Application Reference: 2026/0142

Site Address: 6 Castle View, Green Moor Road, Green Moor, S35 7DQ

Proposal: Erection of a single storey side and rear wrap around extension following the removal of the existing side conservatory and rear outbuilding as well as the erection of a porch at the front.

Title  
**EXISTING & PROPOSED DETAILS**

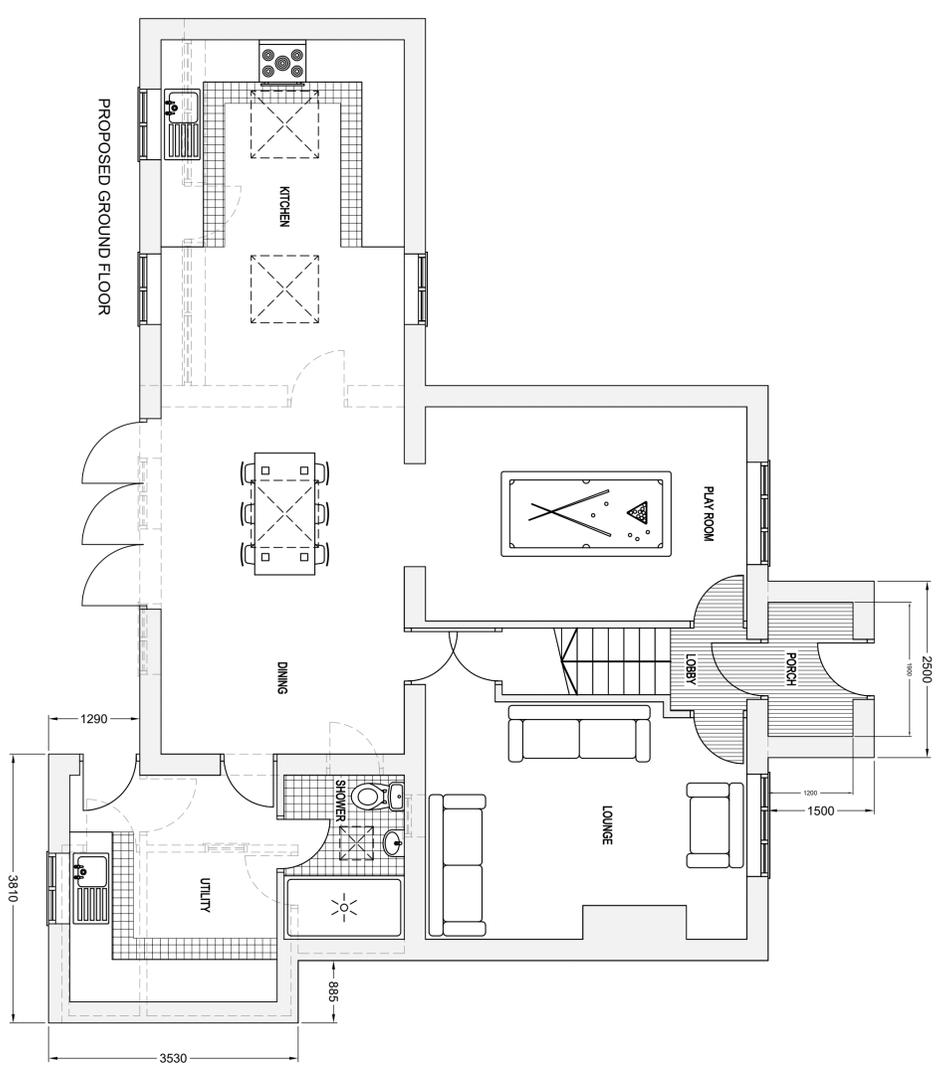
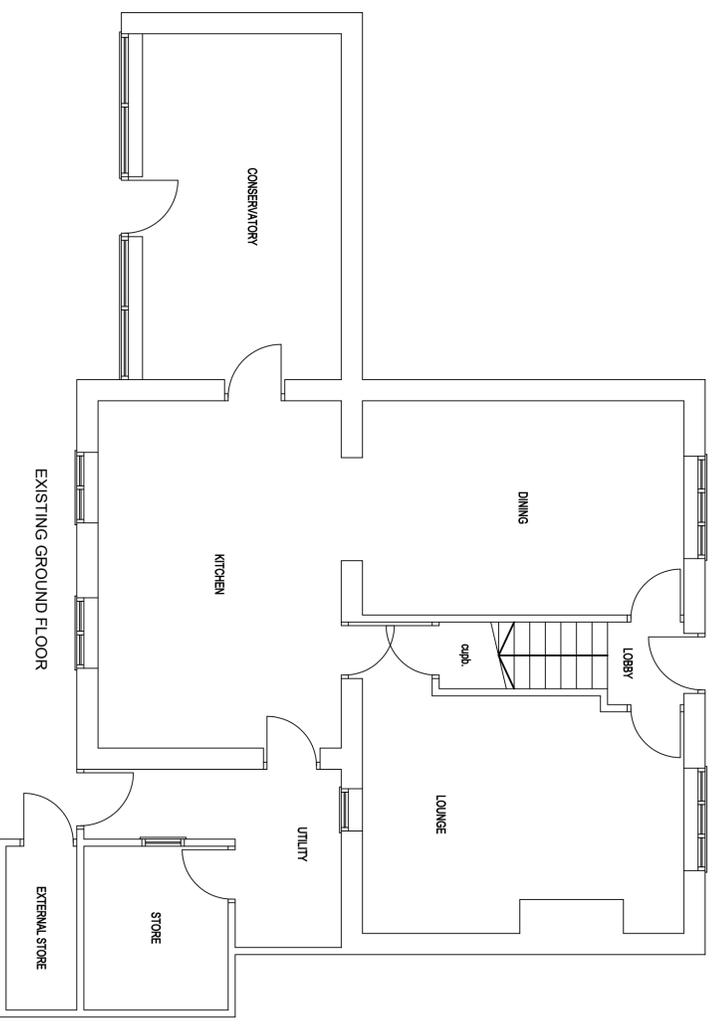
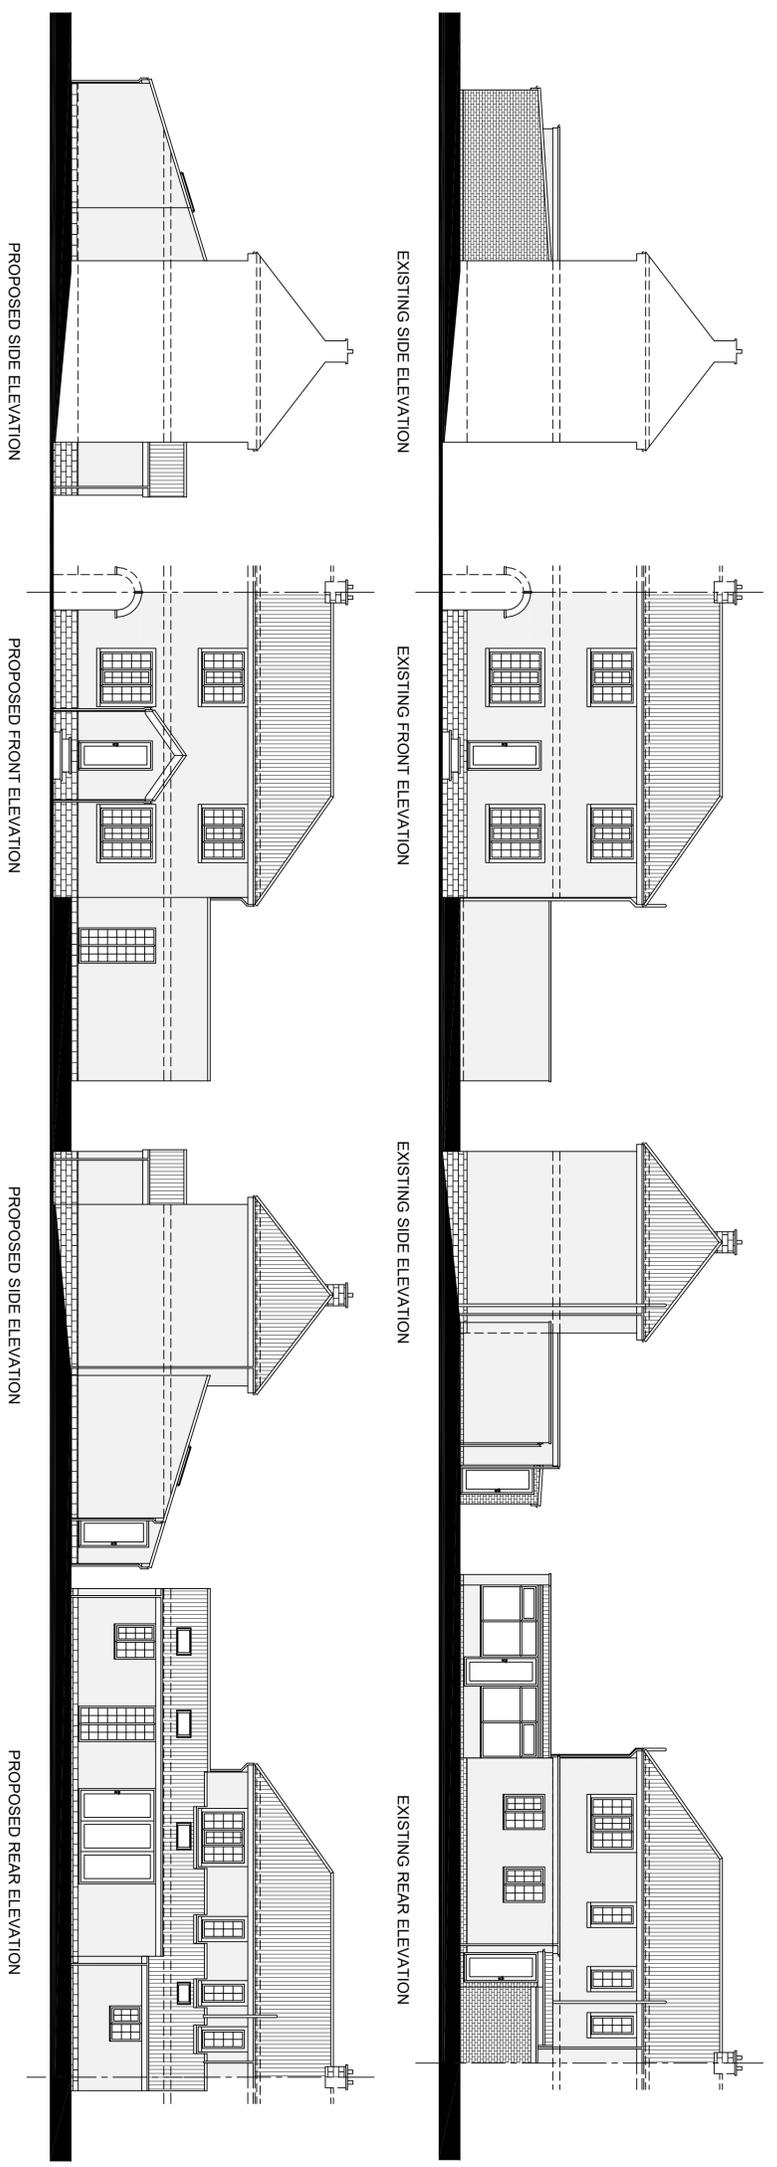
In this case, the existing single-storey rear extension already projects slightly beyond 3.5 metres. It has a flat roof with an overall height of approximately 2.7 metres. The proposal would retain the same footprint and would therefore not increase the projection; however, it introduces a sloped roof with rooflights. As a result, the maximum height would increase modestly to 3.7 metres at the highest point, tapering down to 2.15 metres at the eaves.

Given that the adjoining neighbour benefits from a rear extension of a comparable scale, it is considered that the modest increase in height would not result in material harm to their residential amenity in terms of overshadowing or loss of light, particularly as the proposed roof form slopes away from the shared boundary.

The proposed front porch has no side windows and is sufficient from neighbouring properties not to impact on their amenities.

The proposal includes a modest increase in the height of the side extension, which would be visible from the front of the property. Nevertheless, this increase is minor and would be largely screened by the existing hedgerow, thereby significantly reducing its visual prominence.

The proposed front porch is subservient to the main dwelling and has been designed to harmonise with the host dwelling.
